From: Laura Gibbons <Laura.Gibbons@arun.gov.uk>
Sent: 22 June 2021 15:50
To: Planning.Responses <Planning.Responses@arun.gov.uk>
Cc: Simon Davis <Simon.Davis@arun.gov.uk>
Subject: RE: Planning Re-Consultation on: AL/49/21/DOC

Application No: AL/49/21/DOC
Registered: 27th April 2021
Site Address: Springfield Hook Lane Aldingbourne PO20 3TE
Grid Reference: 493480 104546
Category: Discharge of Condi
Description of Works: Approval of details reserved by condition imposed under ref AL/64/20/PL relating to Condition Nos 5 - pre-commencement site meeting with Tree Officer, 6 - mitigation method statement, 7 - archaeology, 8 - Construction & Environmental Management Plan, 13 - detailed level survey, 14 - materials & finishes, 15 - details of all new screen walls & fences, 16 - landscaping, 18 - energy efficiency measures, 19 - covered & secure cycle parking spaces, 21 - broadband, 22 - charging of electric vehicles and 25 external lighting.

I am able to inform you that I have received an amendment to the above application dated 9th June 2021 relating to: Amendments re conds 6, 13, 15 & 16

IMPERIAL HOMES LIMITED			
CLIENT		HOOK LANE ALDINGBOURNE	
TITLE	TJK1973	SHEET	SHEET 1 OF 1
JOB NO.		DATE	MAY 2021
CHECKED BY	S.K.	DRAWN BY	T.J.K.
LEVEL DATUM	Stn GPS on survey issued		
		SCALE	1:200

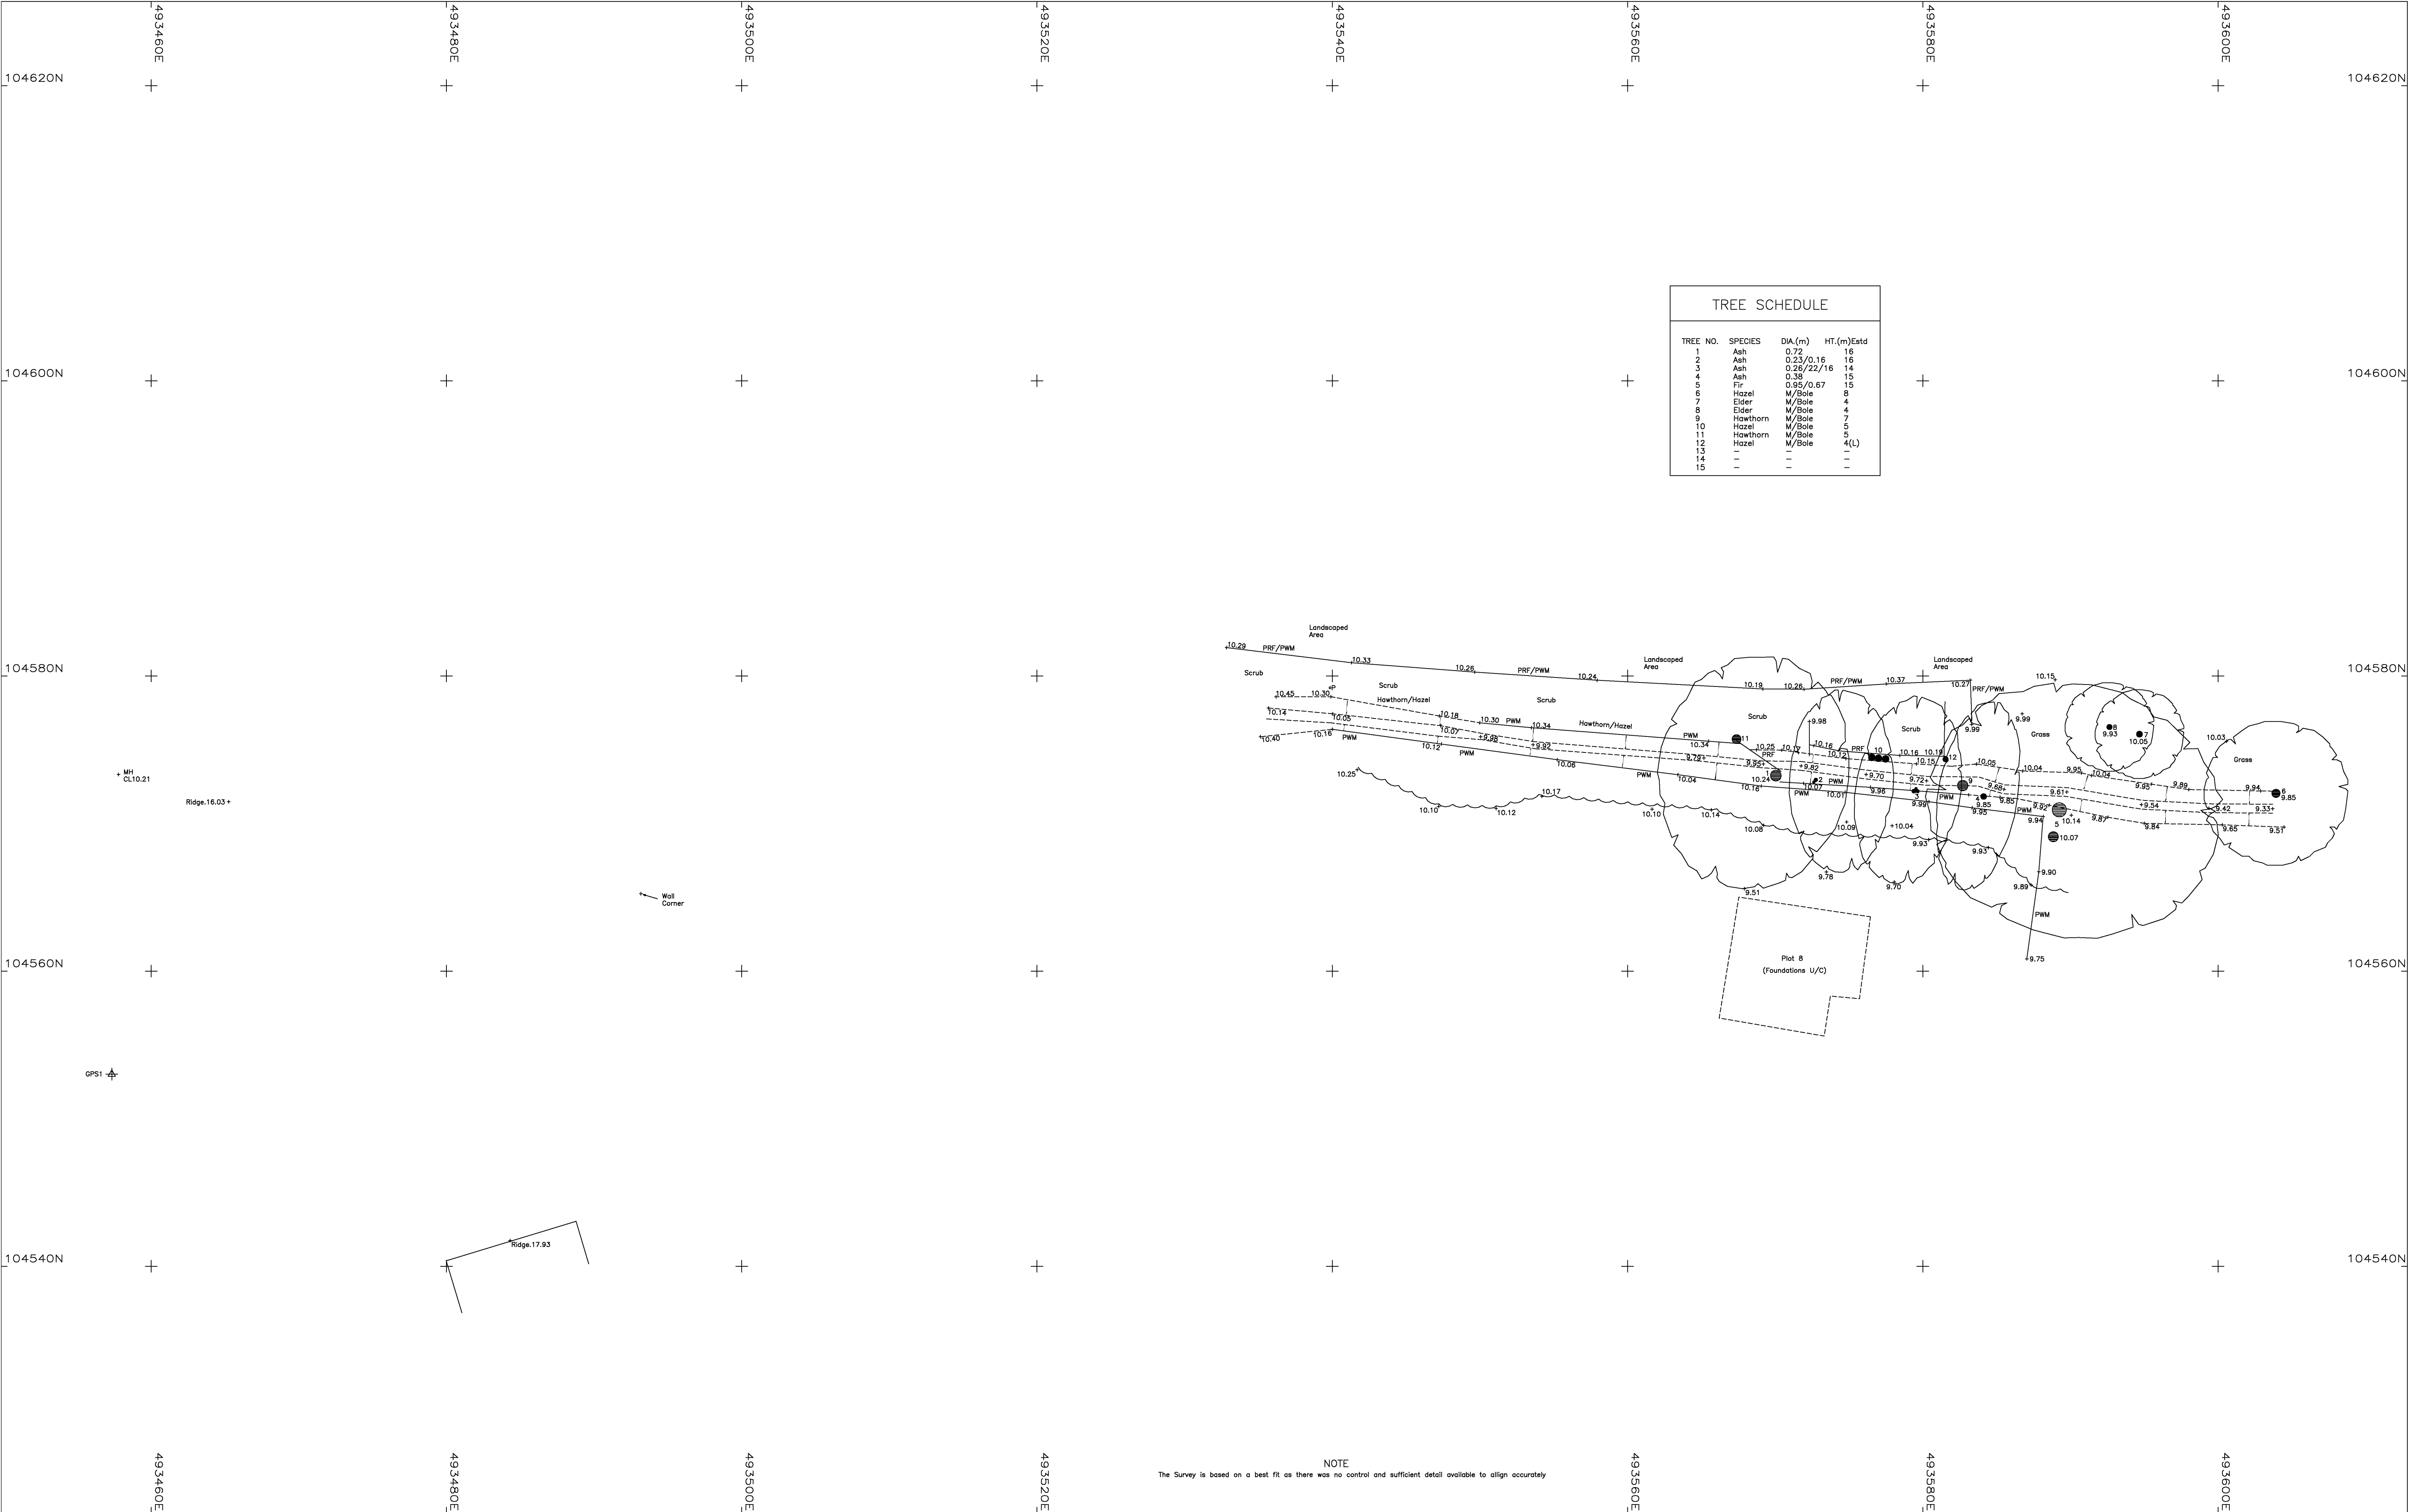
The requirements of the condition for an up to date levels survey of the ditch have not been met. The ditch survey does not extend sufficiently far. The survey should include details of the downstream pipe invert.
